**O.P.W Ref No. 219-2024**

**Case Ref. PAX91.323448 Permission for windfarm located in the Townlands of Garrane, Ballynagoul, Greggane and Chareville, County Limerick**

**ACP- PAX91.323635/ 323448-25: Proposed Development of the Garrane Green Energy Windfarm Project located within the townlands of Ballynagoul, Creggane, and Garrane, Charleville and Kilmallock, County Limerick**

Figure 15.3 National Monuments within 10km of Site

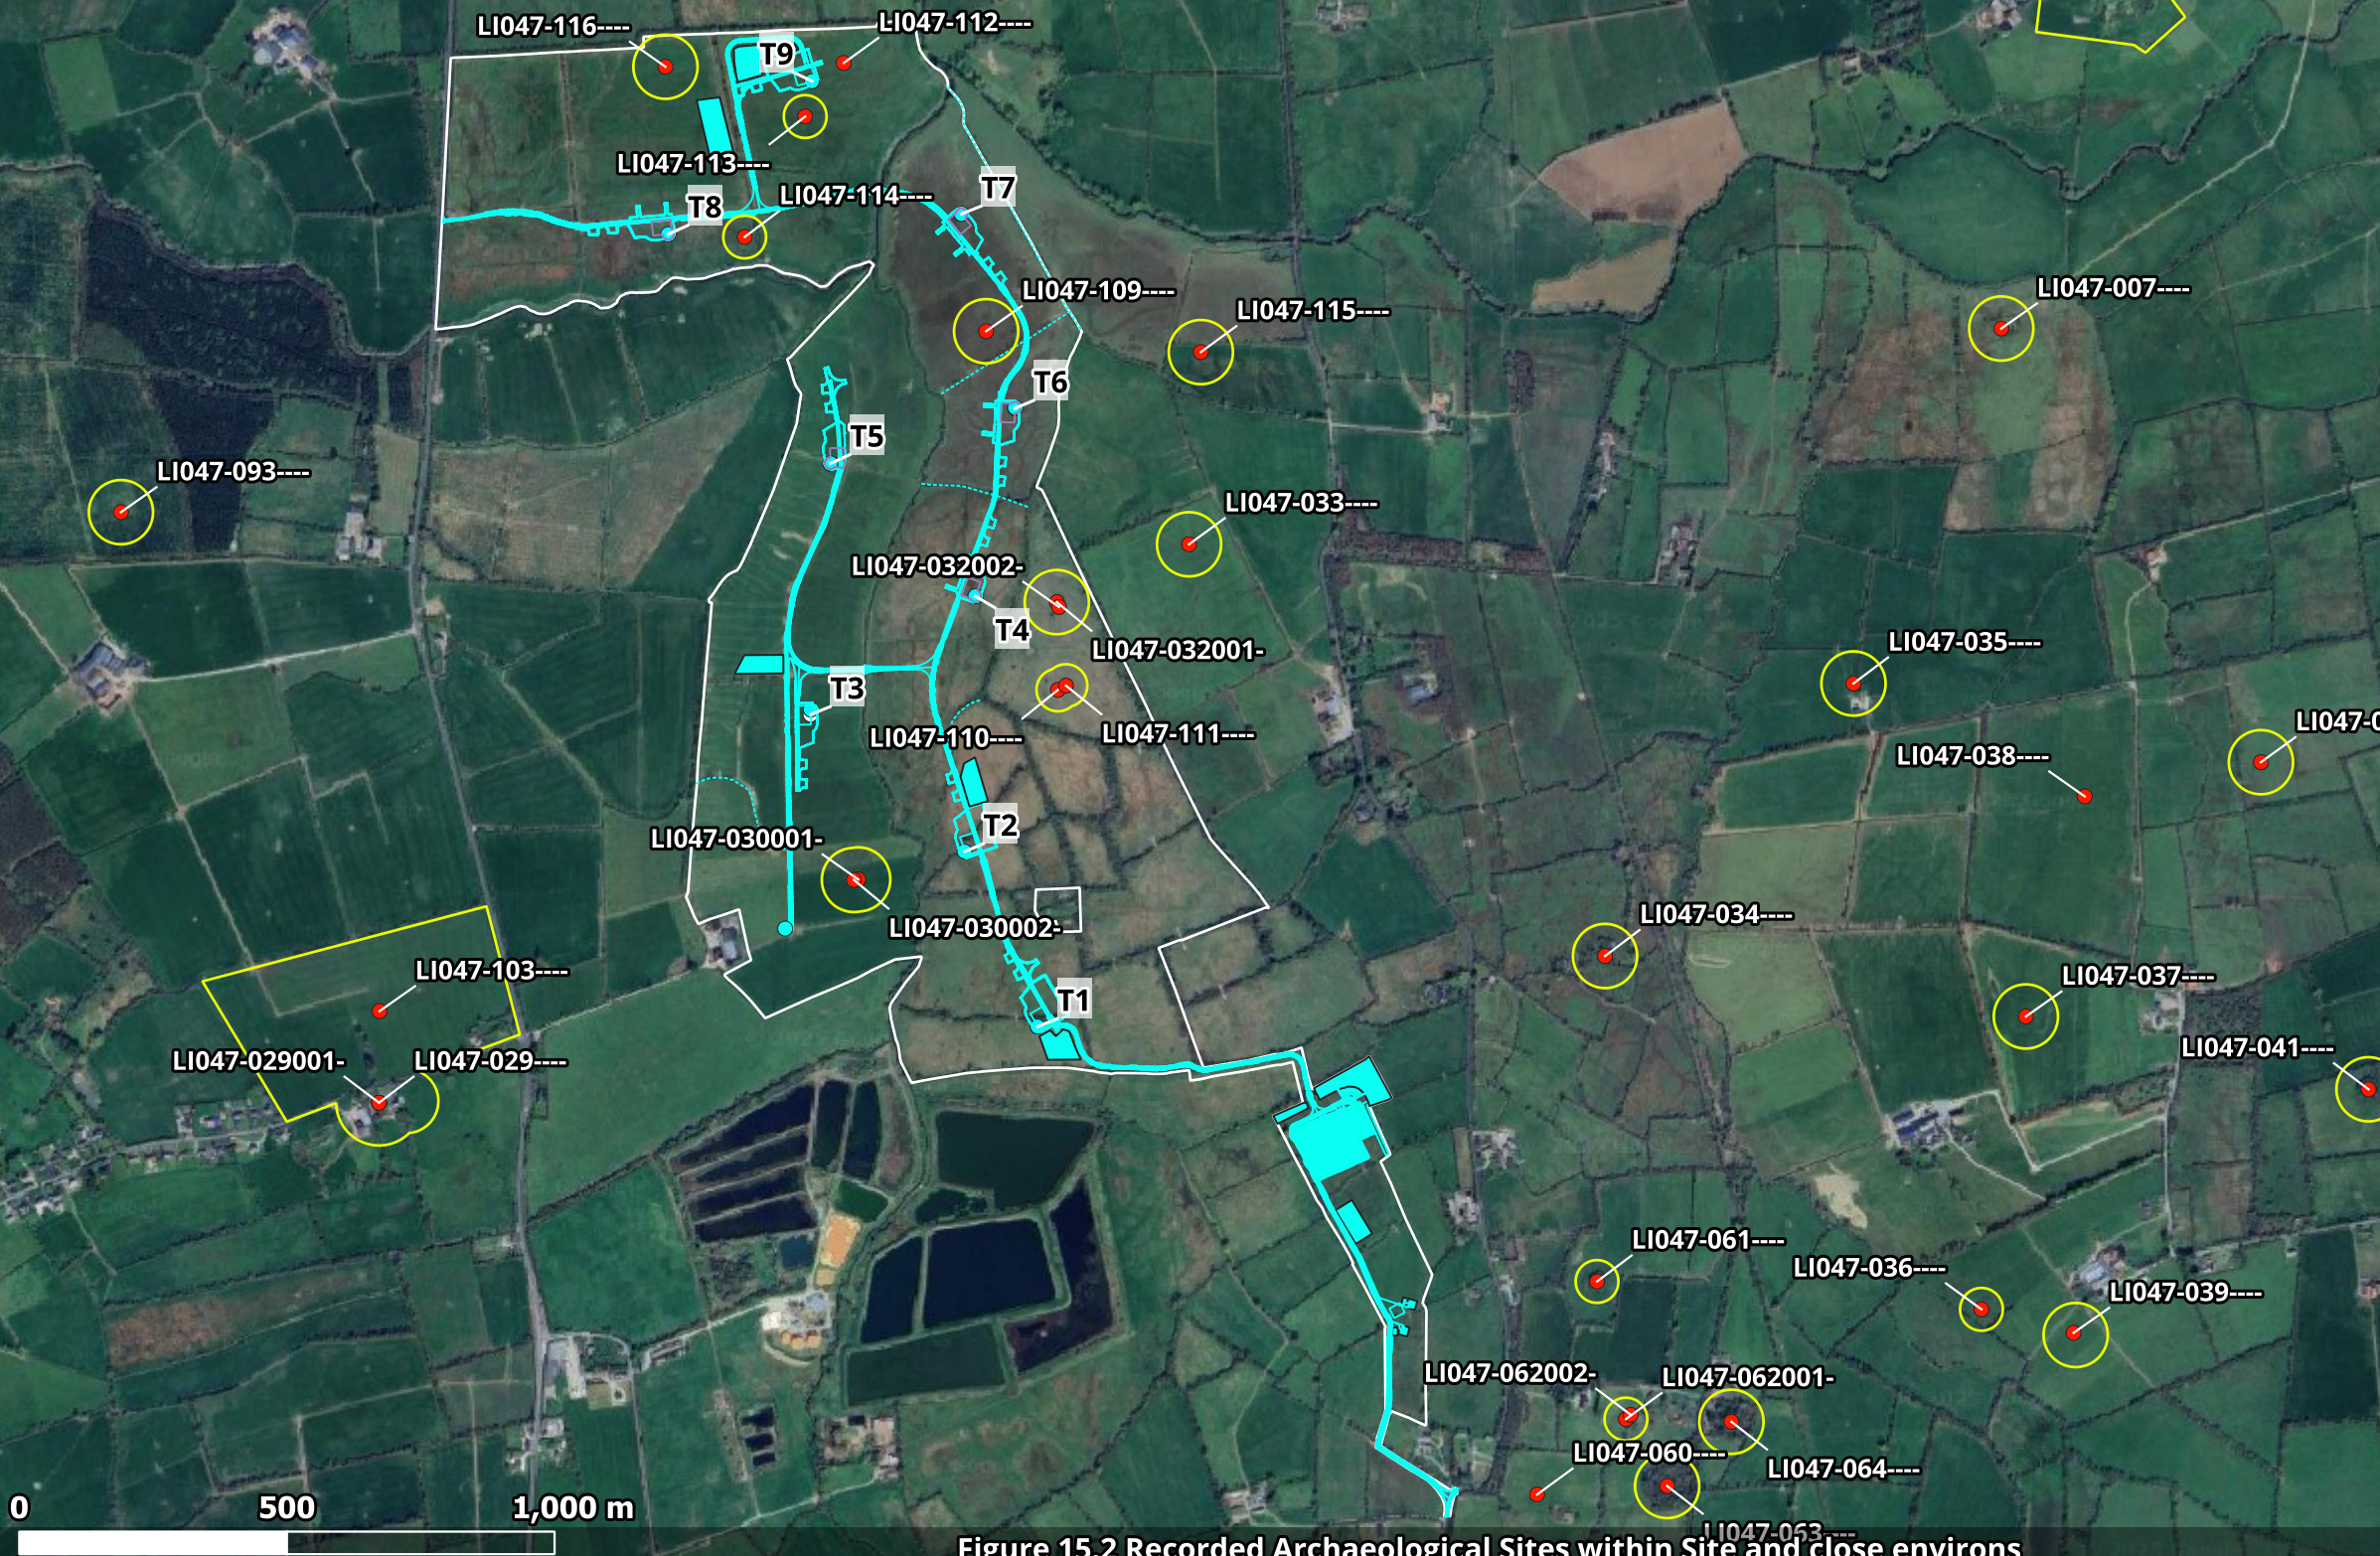
#### **Kilmallock NMs No.s 212, 408, 173, 680 (4.5 km)**

The application has assessed the impact on a view from Kilmallock GAA club (VP11) as low-negligible in magnitude on the basis that blade sets are partially visible above the dense band of mature vegetation in the distance, and on the presence of manmade structures within that view. The submission extrapolates that the same will apply to the 4no. National Monuments in State Care. The OPW notes that the impact assessment is relying on screening by trees, which, if deciduous will provide reduced screening for half of the year, and which may be prone to normal and climate change accentuated risks such as storm, pest and disease damage and/or loss. In addition, if the trees are outside the ownership and control of the applicant, the maintenance of the screening effect is outside of their control. The OPW requests that An Coimisún Pleanála seek verifiable visual impact as additional information

(e.g. wireframe/ photomontage) to demonstrate the visual impact, if any, on these statutorily protected heritage properties. Any impact assessment should include cumulative impacts.

### **De Valera's Cottage NM 576 (3.9km north)**

Despite the proximity of De Valera's cottage, the visual impact on this heritage property has not been undertaken. The OPW requests that An Coimisún Pleanála seek verifiable visual impact assessment documentation as additional information (e.g. wireframe/ photomontage) to demonstrate the visual impact, if any, on this statutorily protected heritage property. Any impact assessment should include cumulative impacts.

### **Liscarroll Castle NM 333 (15 km)**

The OPW requests that An Coimisún Pleanála seek verifiable visual impact assessment documentation as additional information (e.g. wireframe/ photomontage) to demonstrate the

visual impact, if any, on these statutorily protected heritage properties. Any impact assessment should include cumulative impacts.
